**Planning Application, Ribble Valley District
D3-12-0181 3 Woodlands Drive, Whalley**

I have no objection to this application on highway safety grounds following the submission of the amended site plan, Drawing 81/2/1 Revision B.

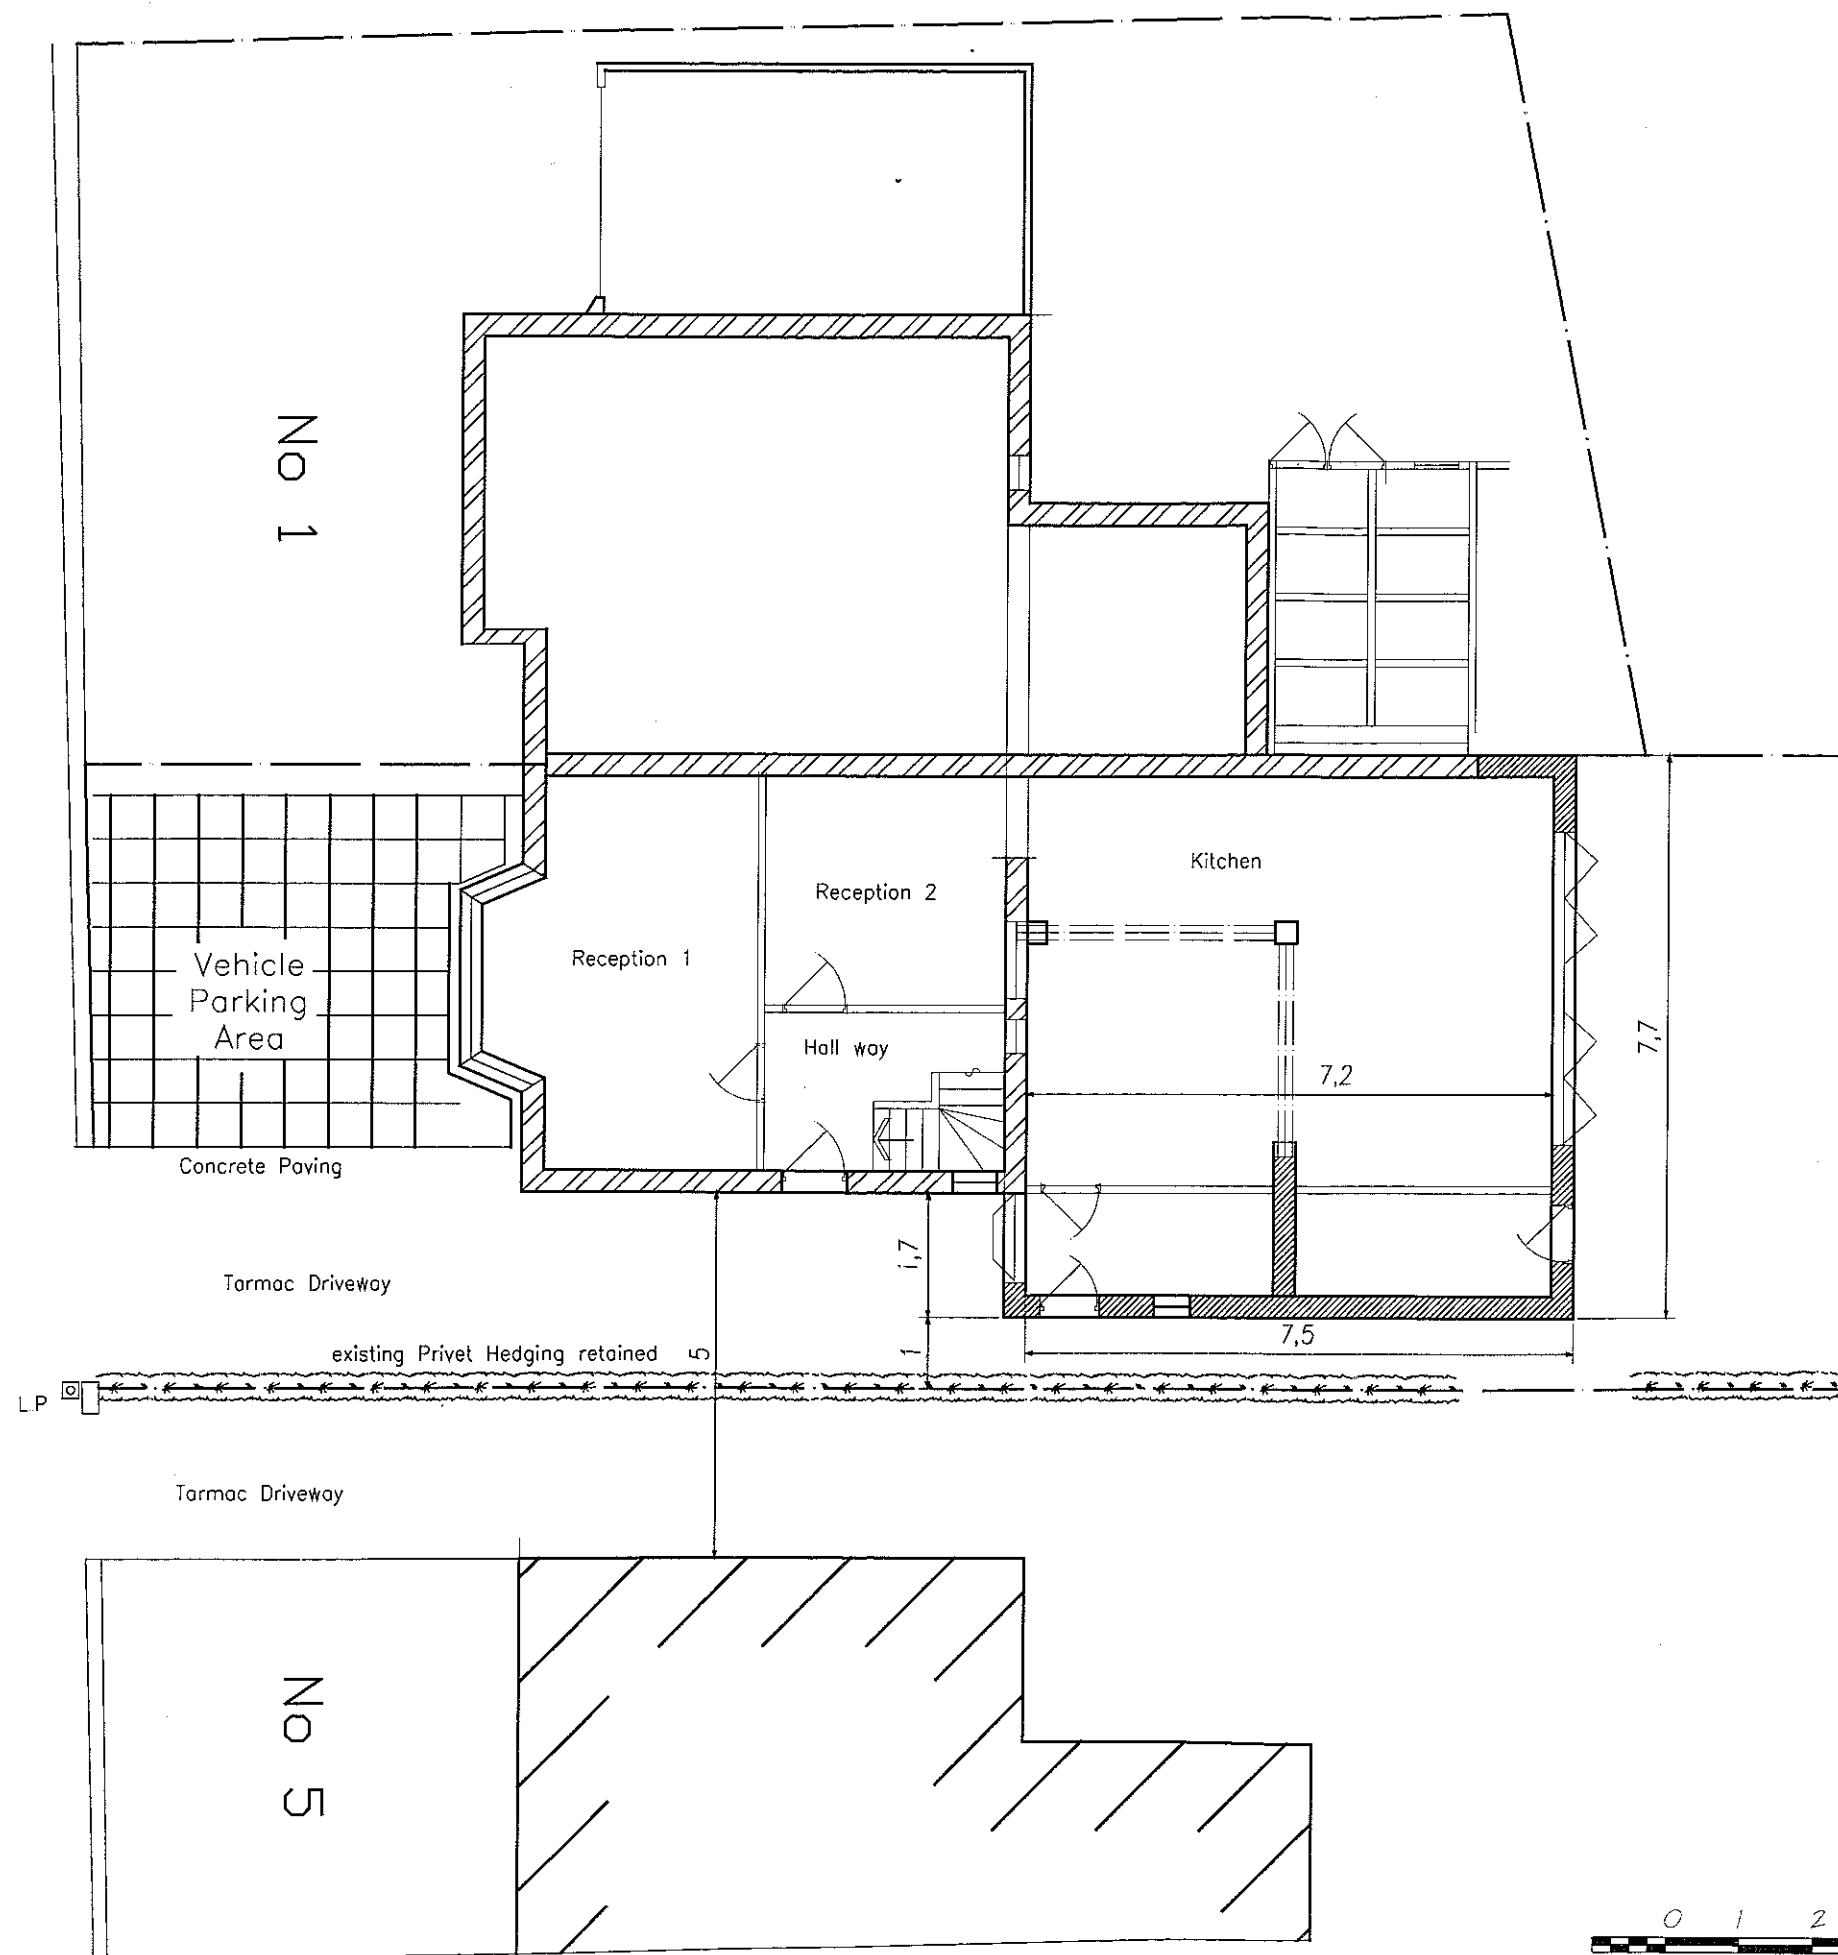
The amended plan indicates that the requested provision for two off street car parking spaces can be achieved from within the curtilage of the site. For a three bedroom residential property at this location off street parking for two vehicles is considered necessary for the activity likely to be generated.

I am satisfied that the provisions set out in the amended site plan referred to above, are sufficient to prevent any detrimental highway safety impacts that may have been identified at this development.
